Conservation Area Advisory Committee

Meeting Date : 7 September 2015

Ref	Description	Address	Design award
LU/237/15/PL	Removal of old front porch & installation of new front porch, replacement of glazing to 2 No. ground floor front bay windows, 5 No. first floor front Georgian sash windows & 2 No. second floor front dormer windows & installation of former railings to forecourt perimeter. This application affects the character & appearance of the Littlehampton River Road Conservation Area. (Resubmission following LU/306/14/PL.)	The White Hart Public House 32 Surrey Street Littlehampton BN17 5BH

PROPOSED SIDE (NORTH) ELEVATION

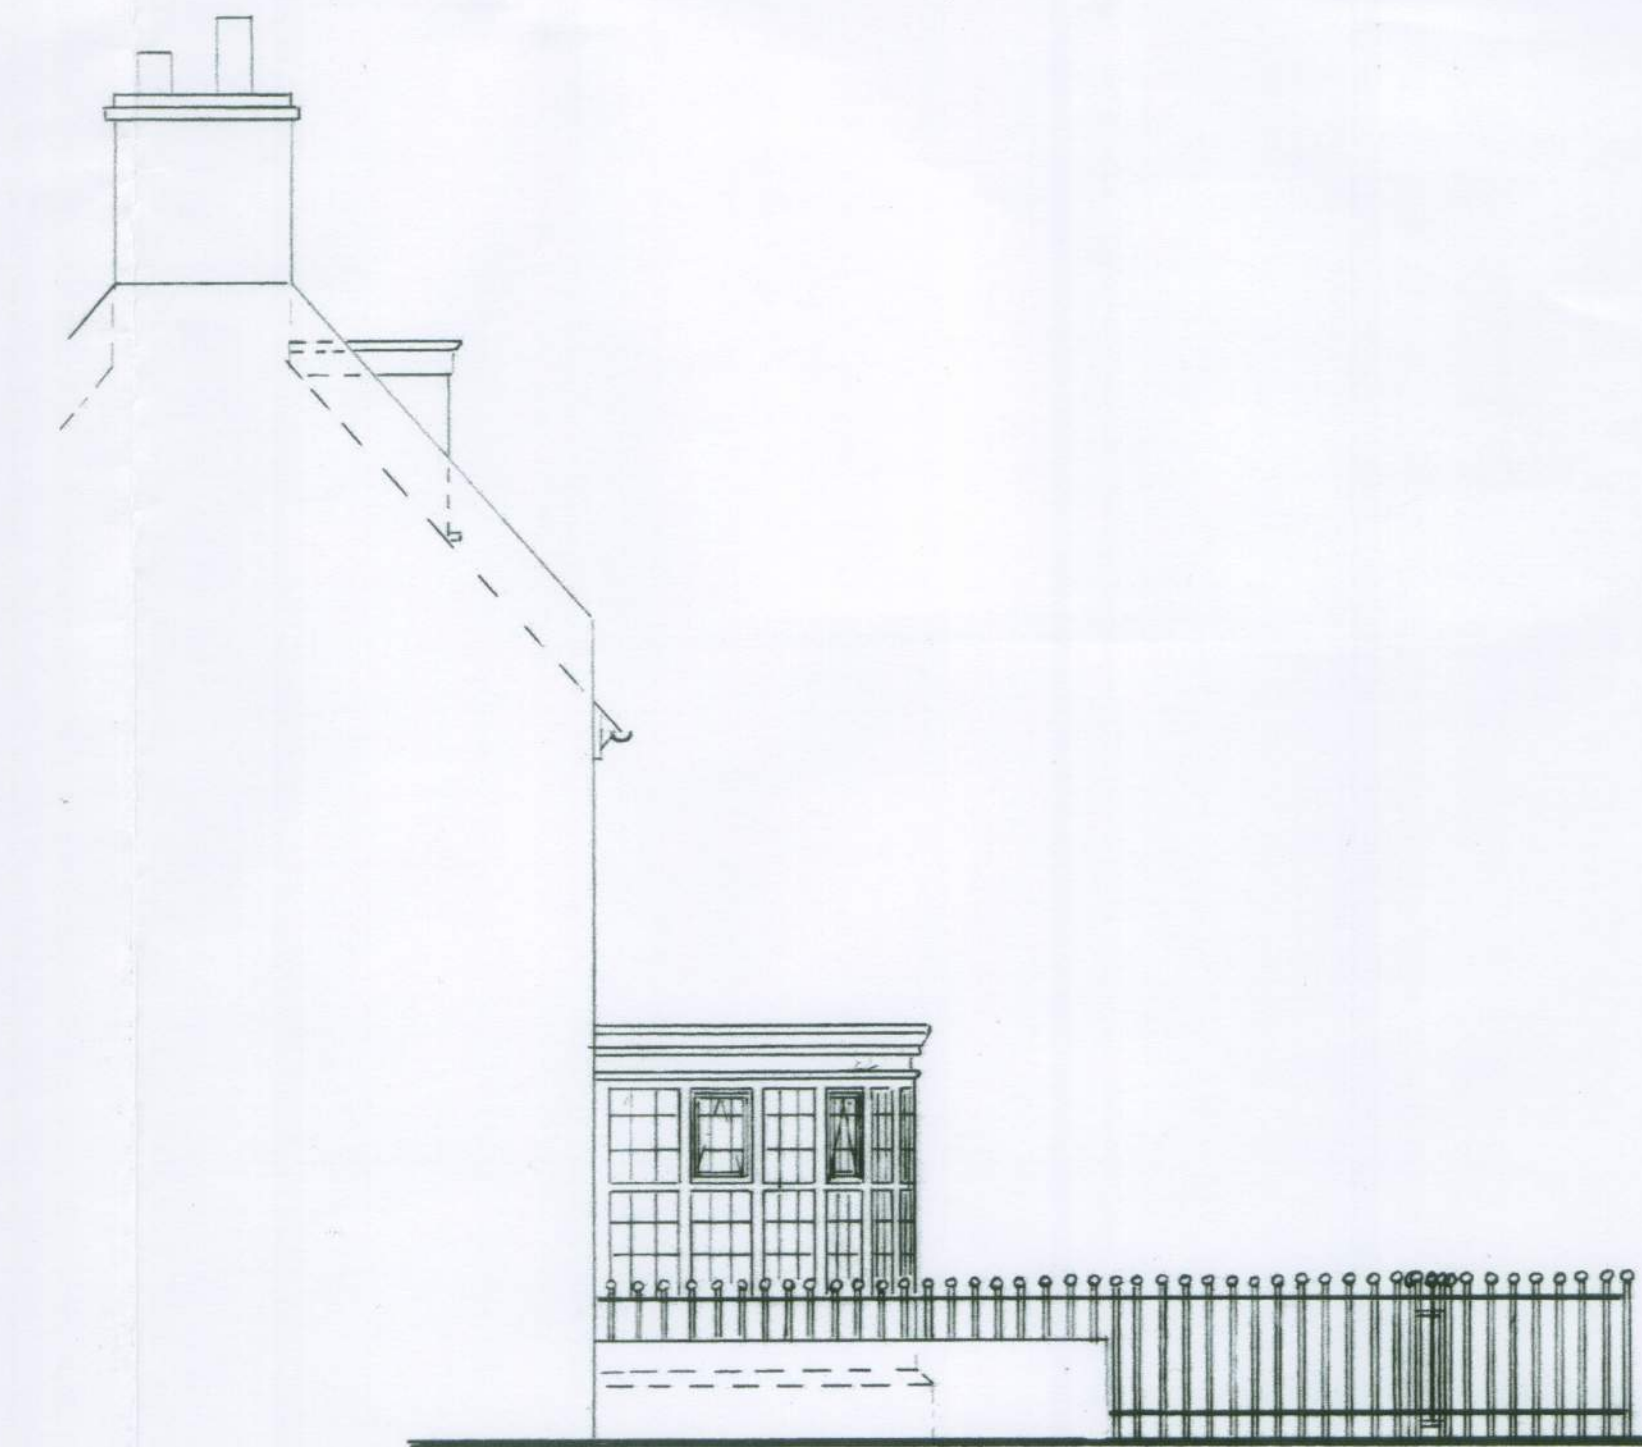
Comments: re Windows - These should be refurbished by specialists & not replaced, retaining as much of the original timber & glass as possible.

Suggested Conditions: the original timber & glass as possible.
Comments re Porch - ~~Objections~~ Would like more detailed plans of porch to enable us to comment - suggest an alternative approach would be to have an internal lobby & remove the existing porch with perhaps a small canopy.

Comments re Railings - Objection - overpaving & out of keeping
Suggest sides only
